# DESIGN PROFESSIONAL INSPECTION FORM

Residential Single Family Project: Y	Commercial Project: N
Code Enforcement Project No:	Permit No: SFD2102-0098
Project Name:	Owner: Ryan Homes
Project Address: Lot 98 Quail Glen – 27 Bird Dog Dr. (Angier, NC)	Suite No:
Date Inspected: 06/10/2021	Contractor Name: Ryan Homes
Component Inspected: Mono-Slab

Describe Element/Component: \* 3rd Party Monolithic Slab Inspection

DRAWING TITLE FOUNDATION PLAN

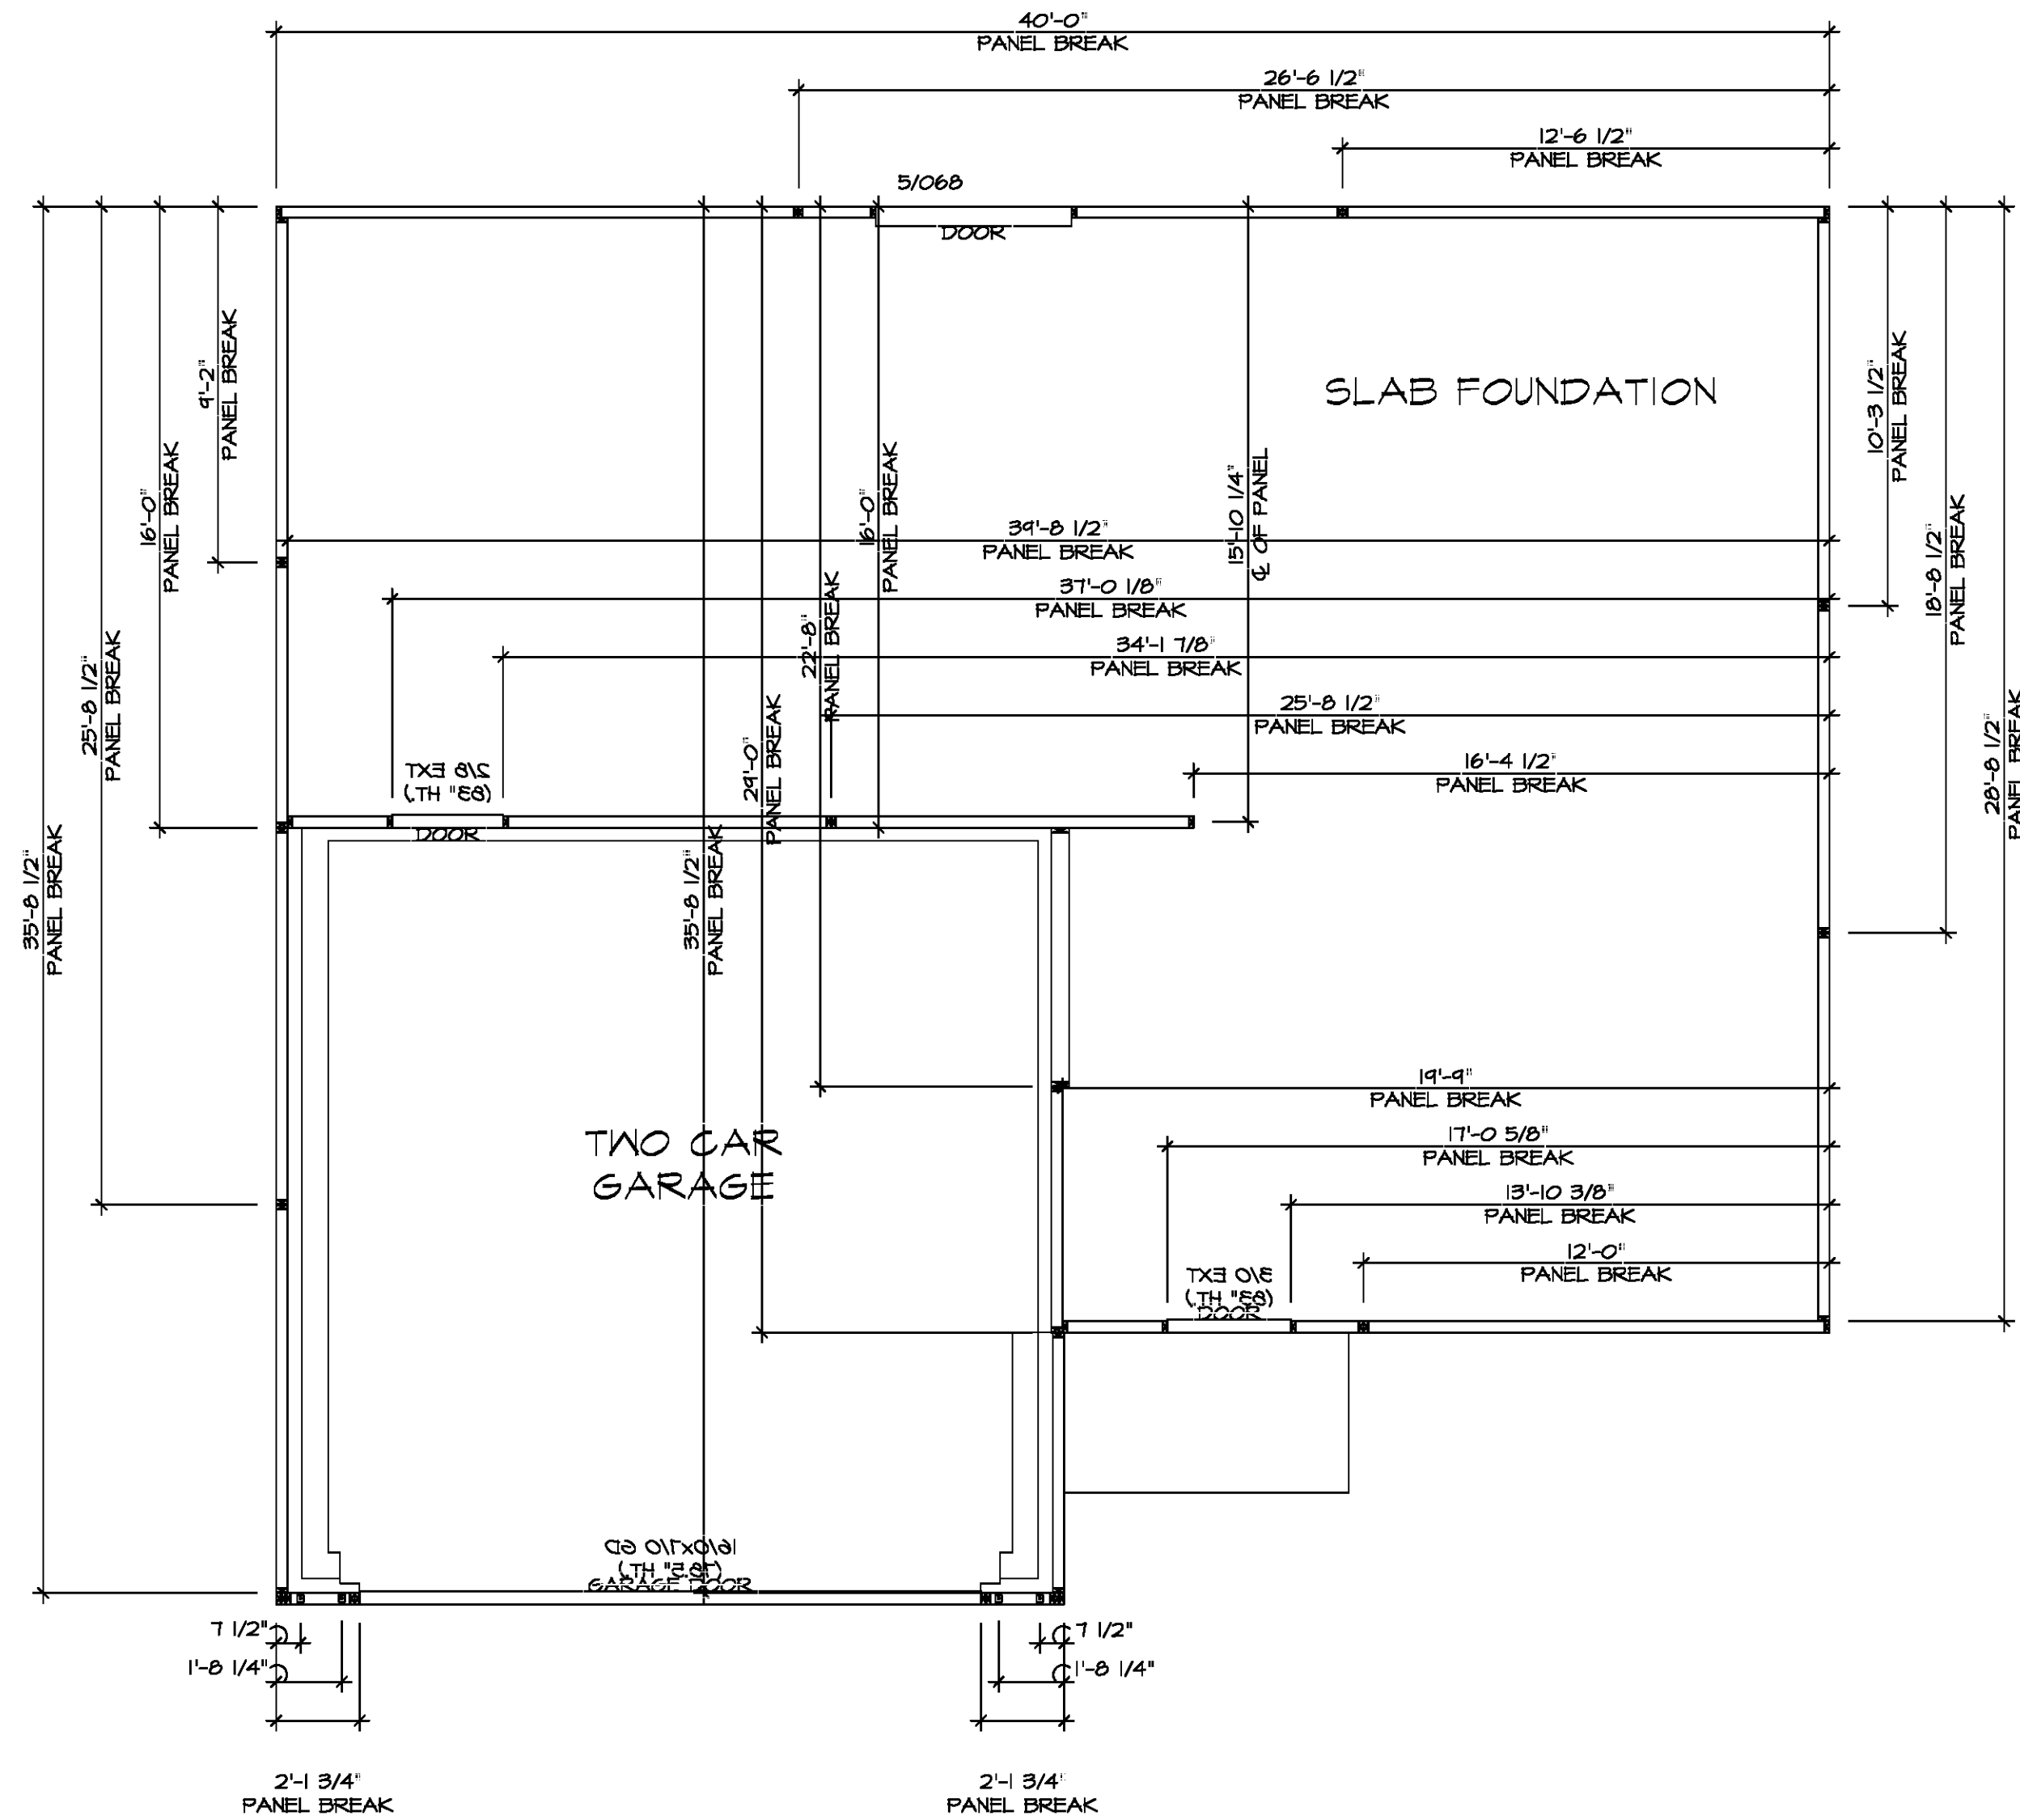
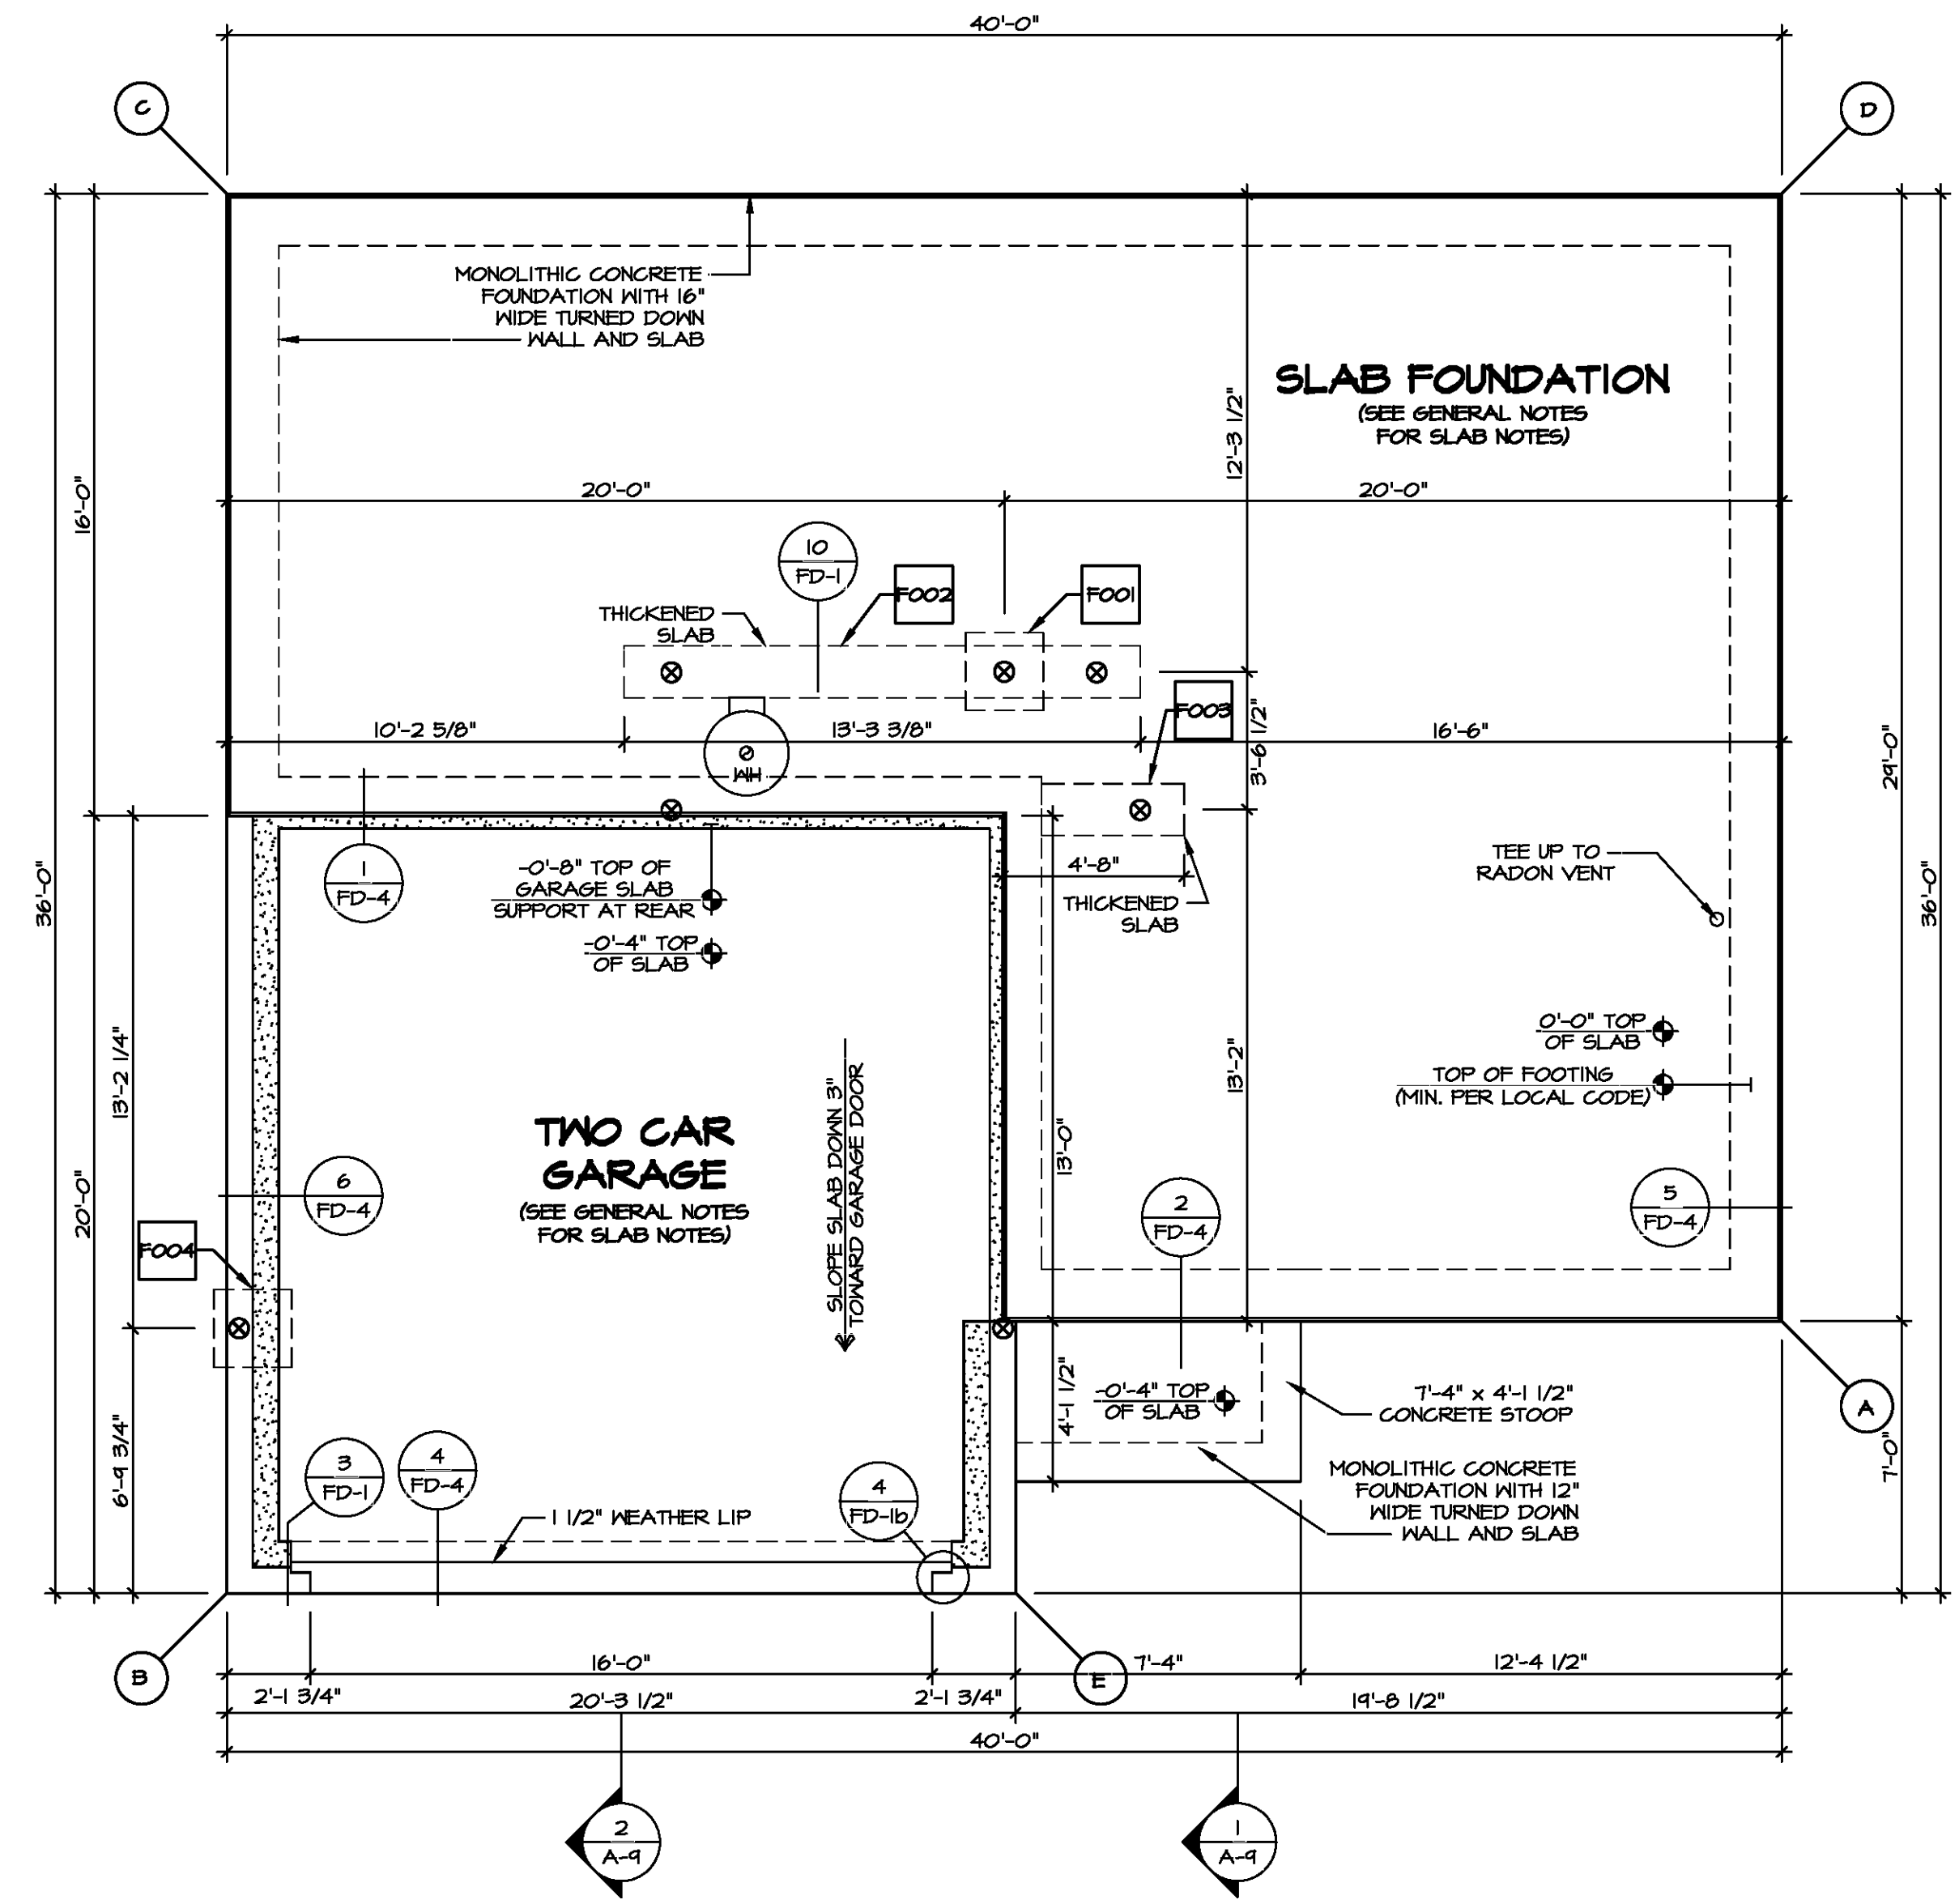
Note: An ERI may be required for final inspection due to missing perimeter insulation at the right and rear of the garage.
